Our reference: ECM: 7660507
Contact: Gavin Cherry
Telephone: (02) 4732 8125

8 June 2017

**Replacement Submission to the Department of Planning and Environment
in Response to a Notice of Section 96(1A) Modification to the Altis
Warehouse and Logistics Hub (SSD 7173 MOD 1) at Nos. 585 - 649 Mamre
Road, Orchard Hills**

Figure 2: Proposed Layout, Lot 8A (Linfox)

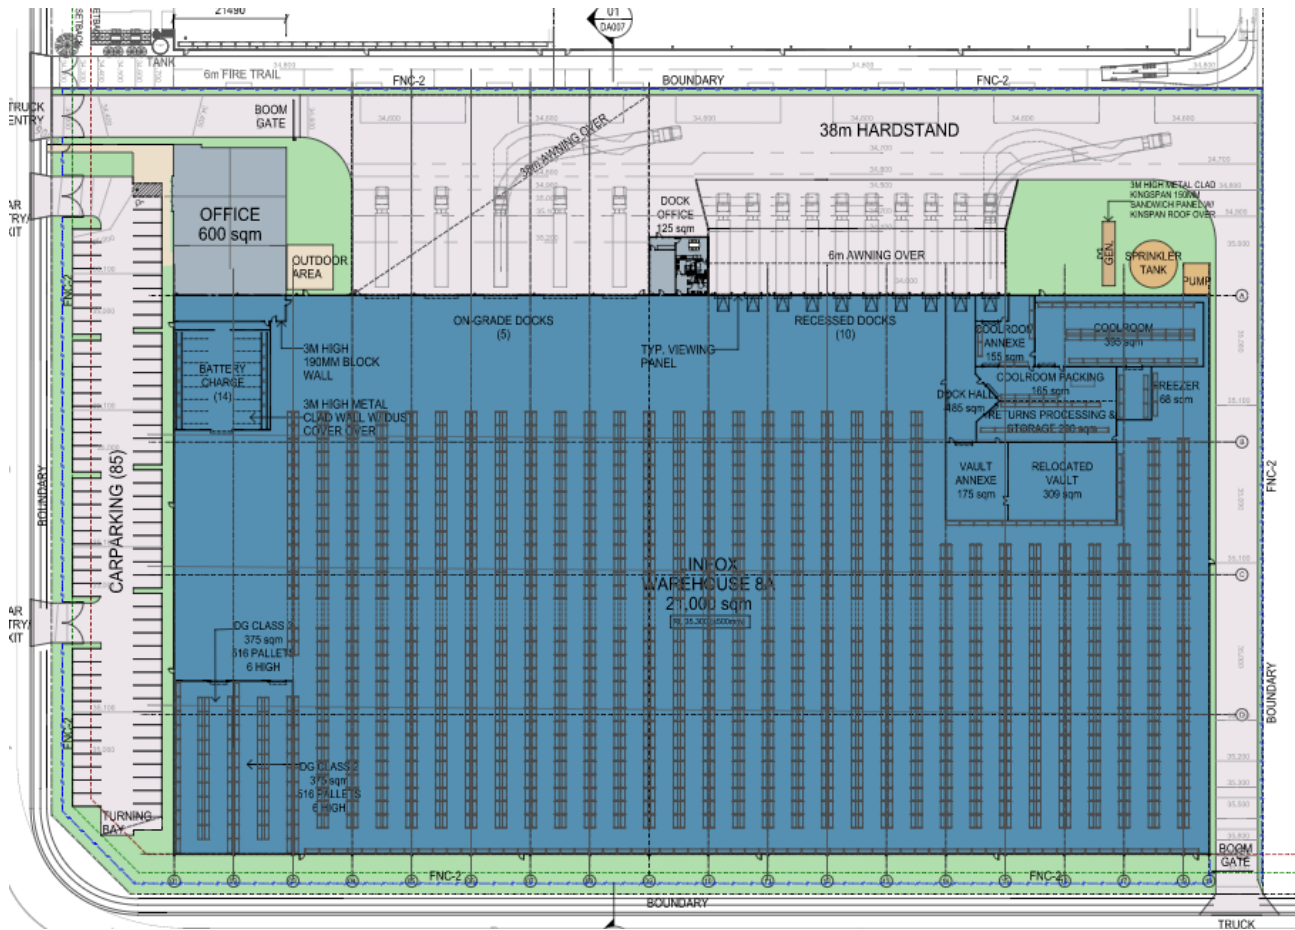
The revised proposal includes changes to the approved setbacks to the internal road network. While the extensions maintain a 7.5m setback to the internal road network, the suitability of the resulting setback is dependent on the landscaping design to the street. The revised plans propose a significant number of driveway crossovers which reduce landscaping potential within the front setback. The provision of an entry and exit driveway for Lot 8B1 and 8B2 as well as a separate driveway access to the new proposed car park should be considered with the potential for increased landscape setbacks to compensate for the hard stand presentation of the driveways and turning areas in the front setback zone. Where the landscape setback cannot be widened, the planting (species, pot size and density) should ensure that a suitable landscape treatment can still be provided (to ameliorate the visual impact of the hard stand area in the front setback zone).

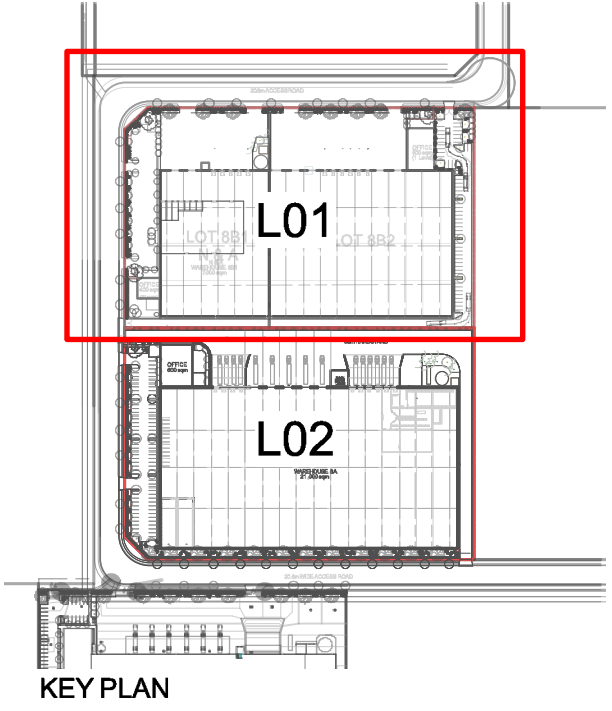
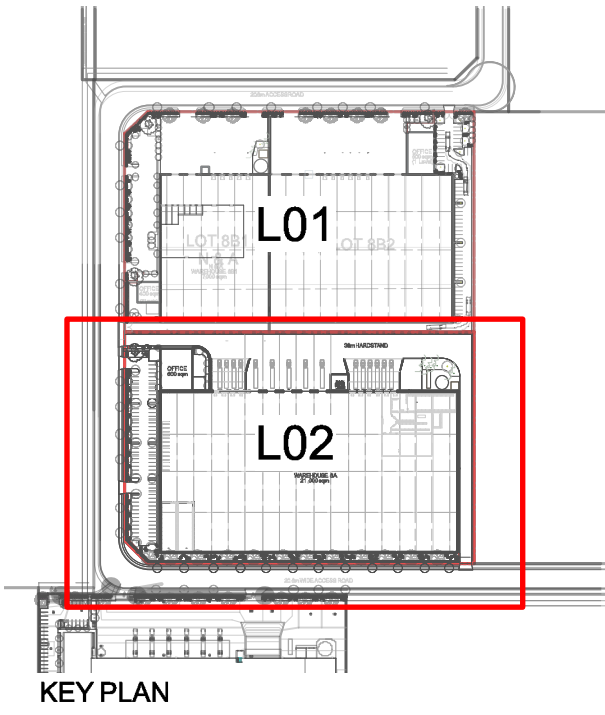
It is also recommended that additional tree planting be required in the notated 'breakout area' for Lot 8B1 to partially ameliorate the presentation of the setback protrusion and also provide canopy cover for the breakout area.
